Application No: M/102/20/HH
Site Address: 17 Old Point Middleton-On-Sea PO22 7RY
Description of works: Single storey front infill extension, single storey side/rear extension and conversion of roofspace to habitable use to include a rear dormer, 7 x side rooflights and balcony to front

Thank you for your internet representation made on 8th February 2021 which has been recorded as an objection with the comments as follows:

Proposed South Elevation n.t.s

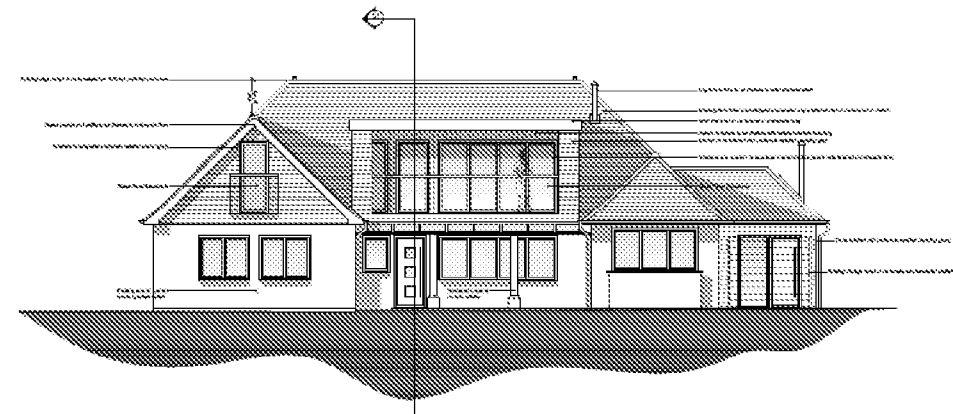
1. The front 1st floor loggia/balcony is disproportionate to the new ground floor elevation.
2. This amounts to an invasion of privacy for the owners of the opposite property, and
3. Conflicts with the Village Design Statement.
